From: Kathryn Welch
Sent: 16 March 2022 09:58
To: Planning Scanning
Subject: FW: Pharos Quay, River Road, Littlehampton - LU/13/22/PL

1. PVCu replacement windows, in principle, would receive your support. Not high gloss finish but with timber woodgrain effect as specified.
2. You are supportive, in principle, of casements and do not see the need for varying the style to vertical sliding sash windows.

3. We discussed advantages of 'horns' on the base of the upper casements but do not feel they add anything to the overall design.
4. I have drafted up a drawing of a typical window (W10) in the existing and proposed format for your assistance. Hope this helps.

DRAWING CHANGE DETAILS:		Towns and Sperm and on added to window & door schedule, sash towns removed	
PROJECT:		Pharo's Planning Drawings, BN11 ZSP	
TITLE:		Window Elevations (Sheet 3 of 3)	
PROJECT NO.:		21-75-869W	
S.I.H.		E3	
CHECKED BY:		P.F.	
SALES PERSON:		Kean O'Neil

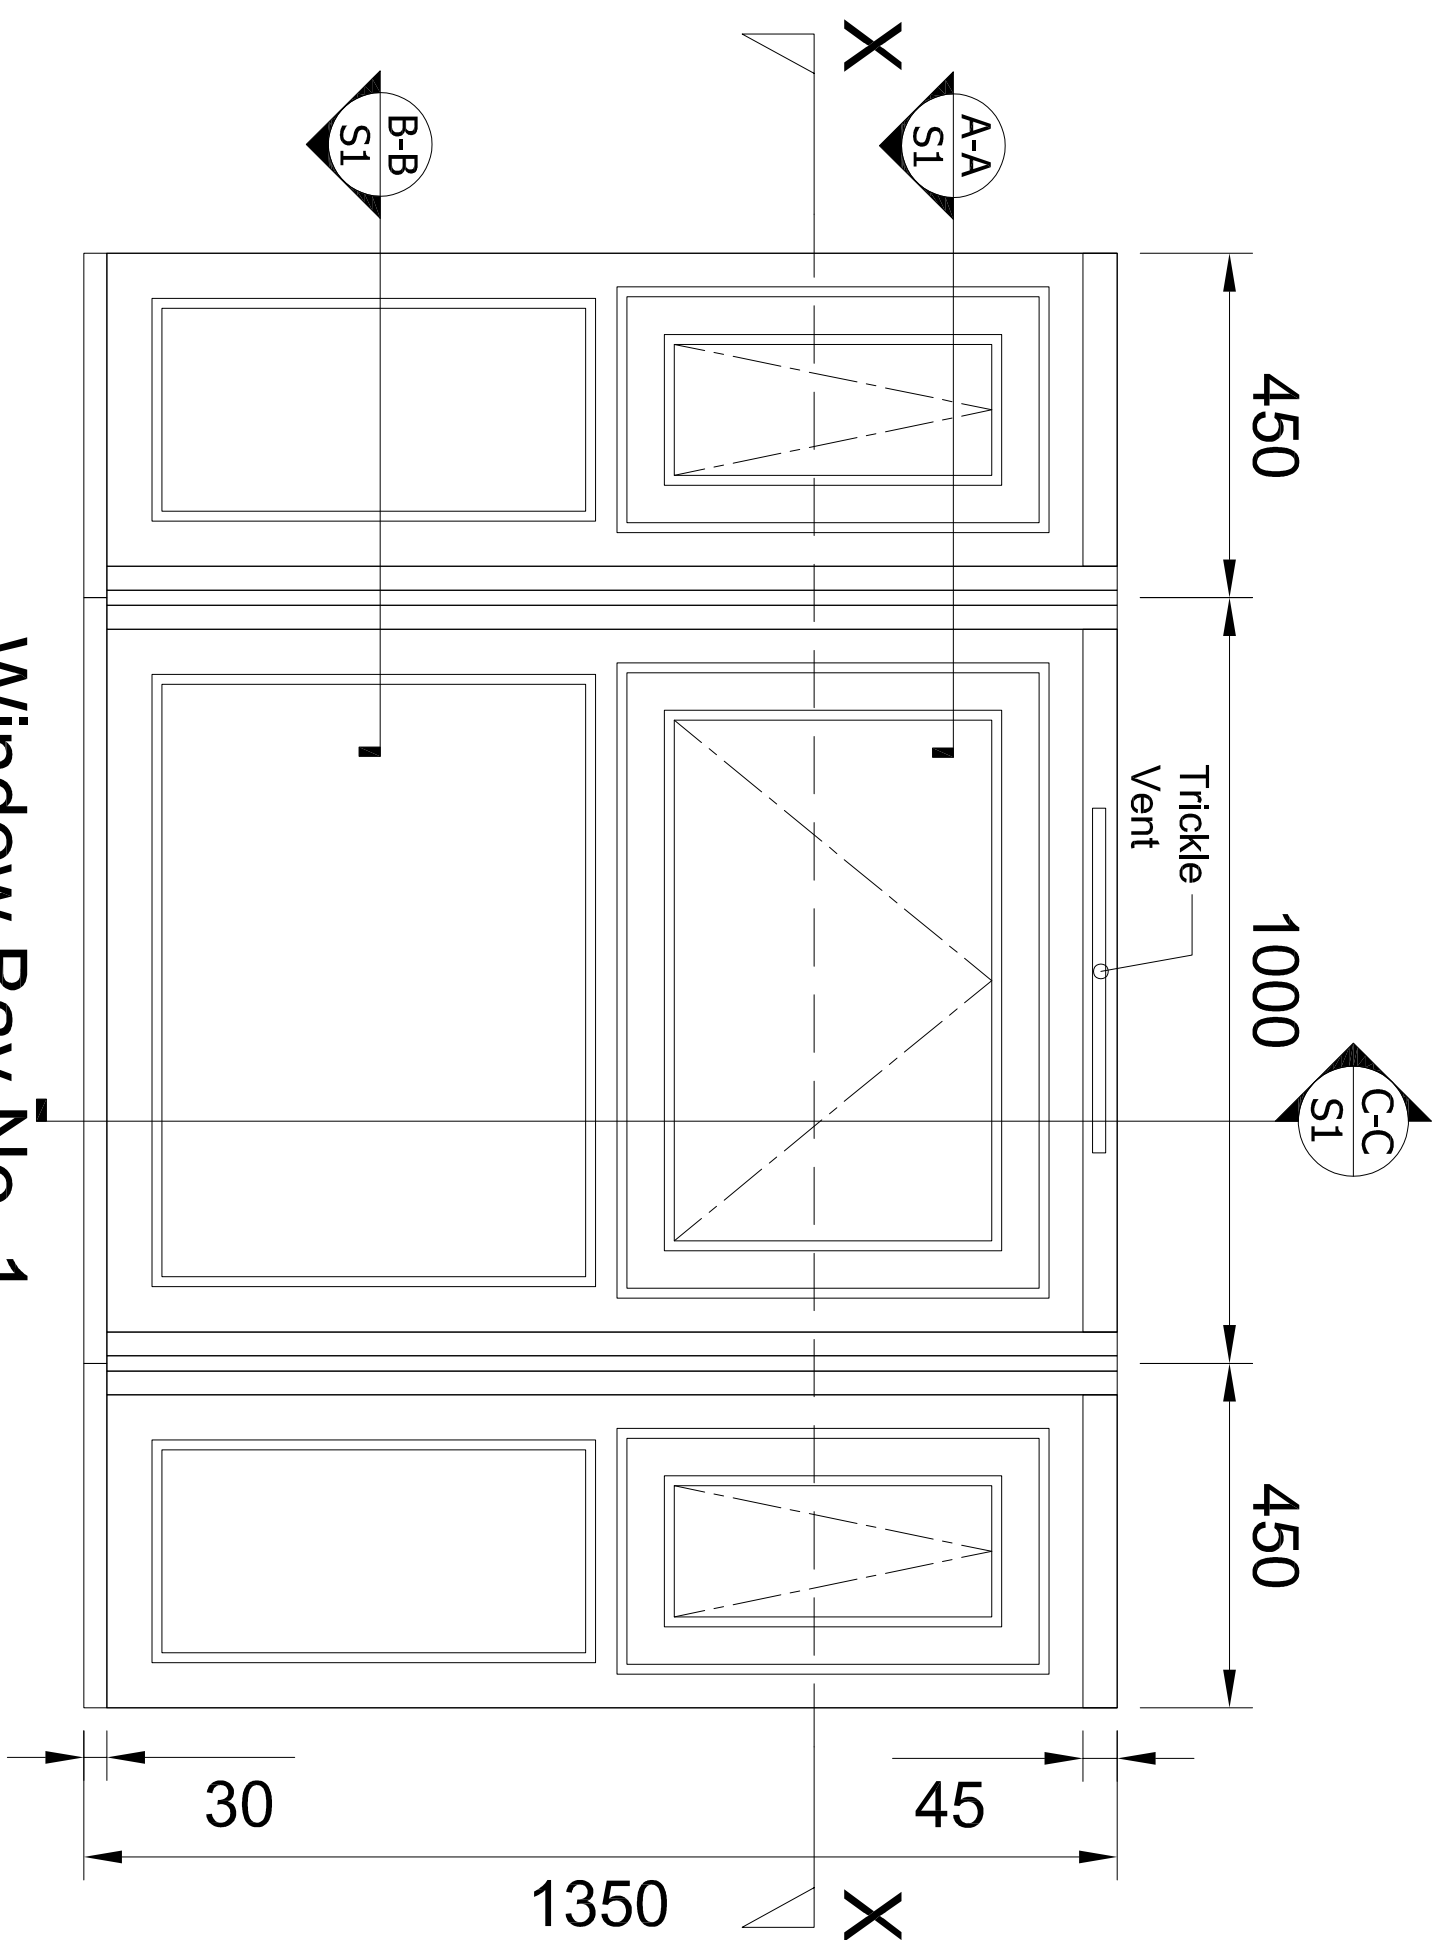
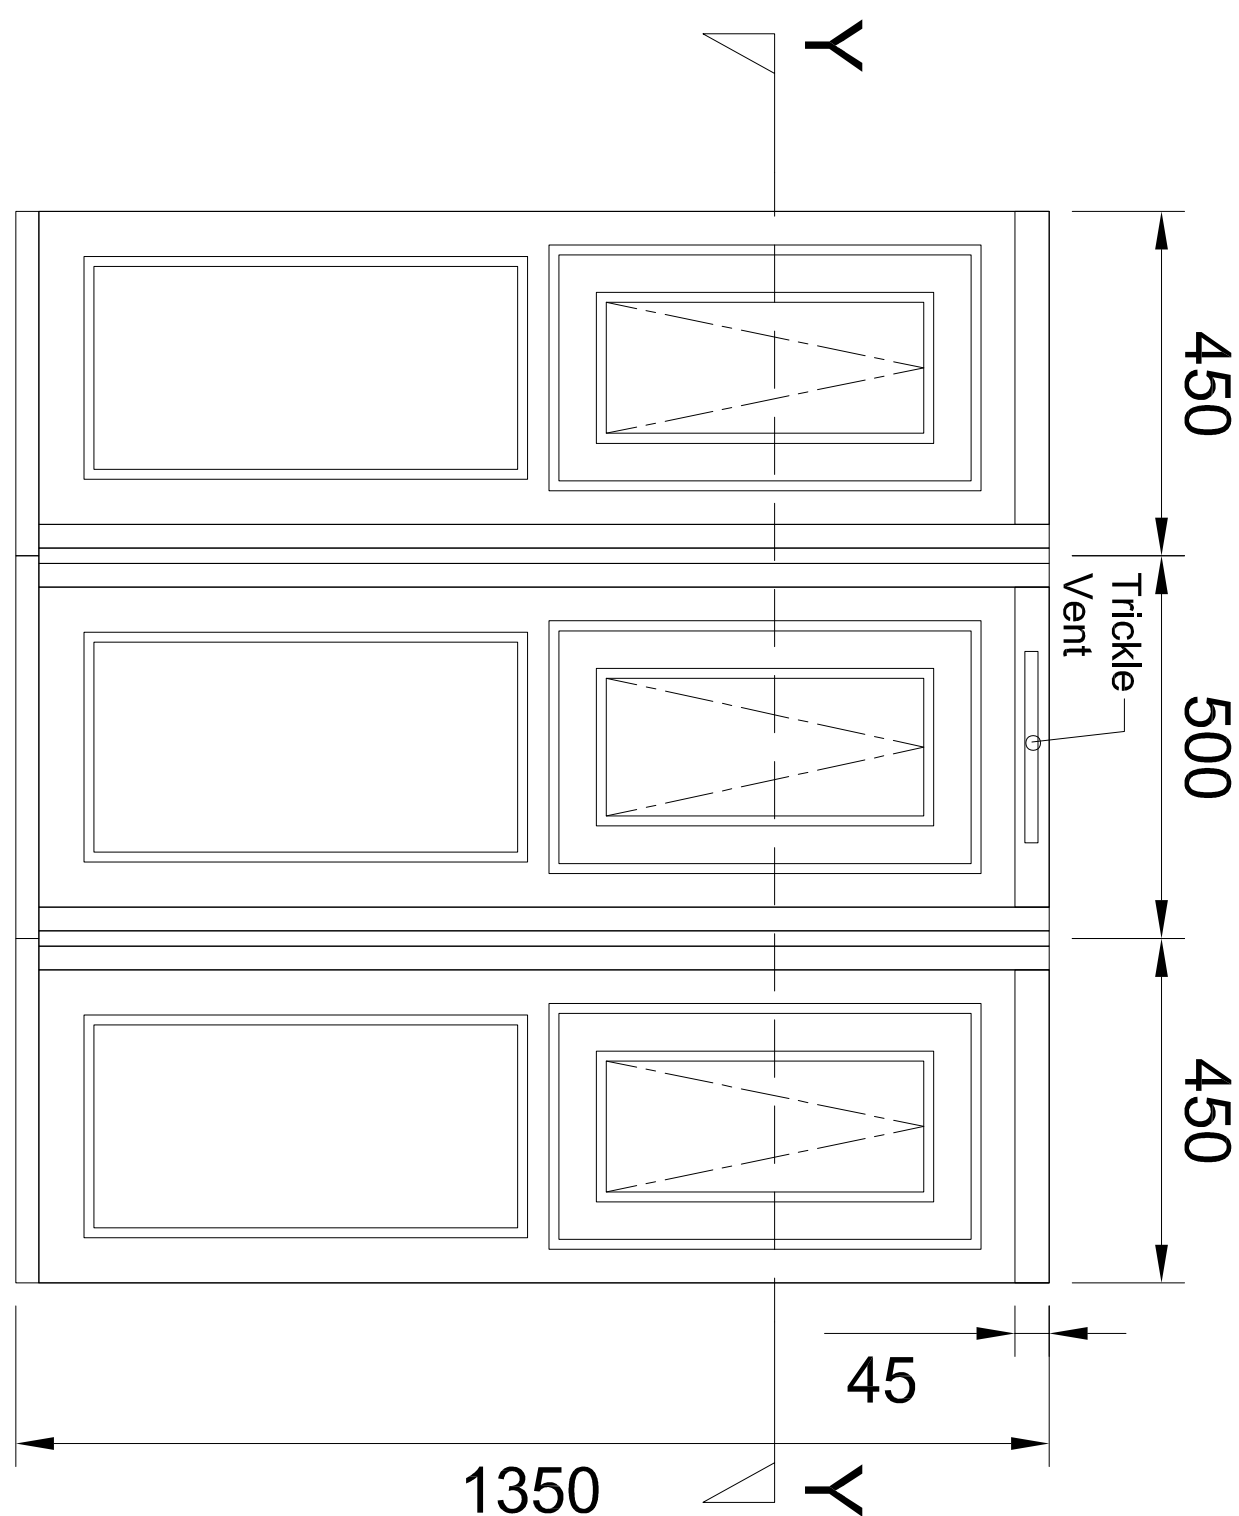
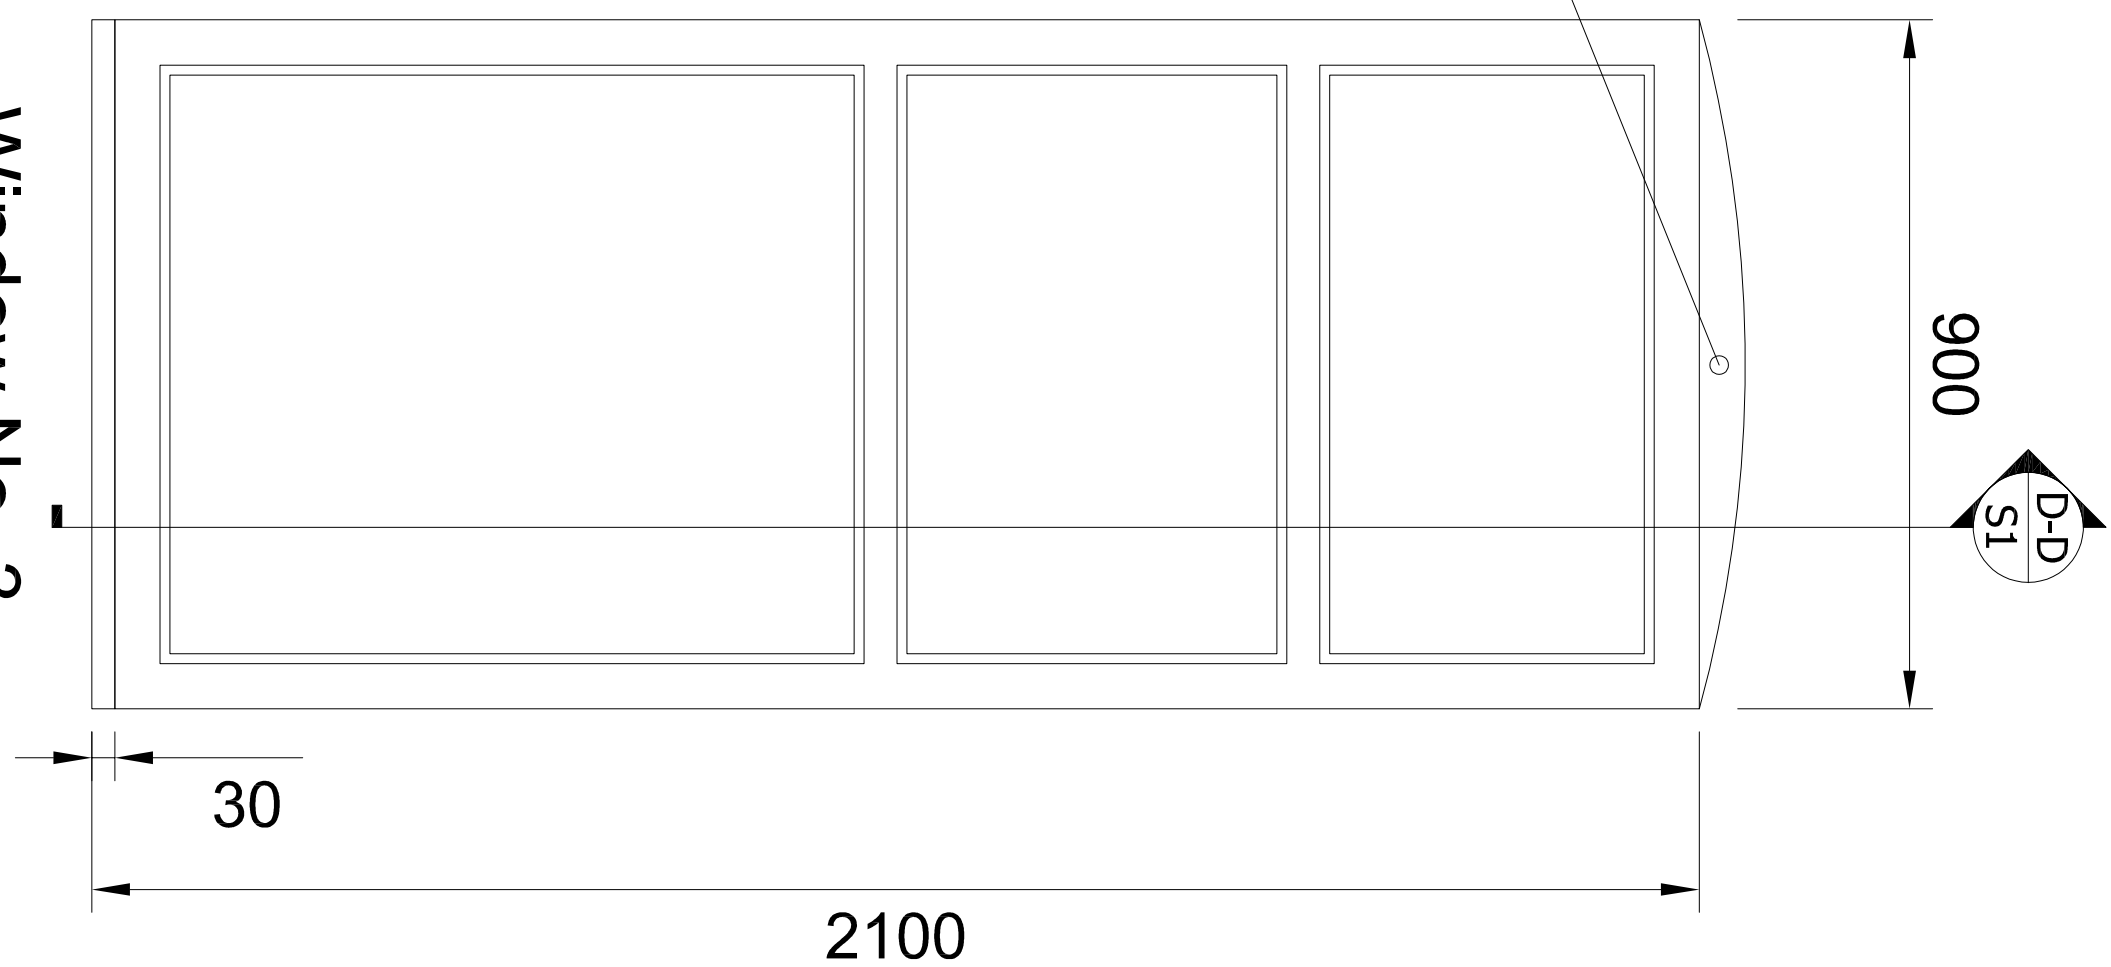
The details sent through for point 4 still look a little 'chunky' to me. As I said over the phone, in order to utilise Upvc windows in heritage locations we normally stipulate heritage glazing, where not only are the glazing profiles slimmer but the frames also. It has been very useful to see the side-by-side comparison, my biggest concern is the upper opening part of the window and not the fixed pane at the bottom, it is significantly larger than the existing timber frame. Is this something that can be rectified? If this can't be done in time I happy to approve with a condition for further details.
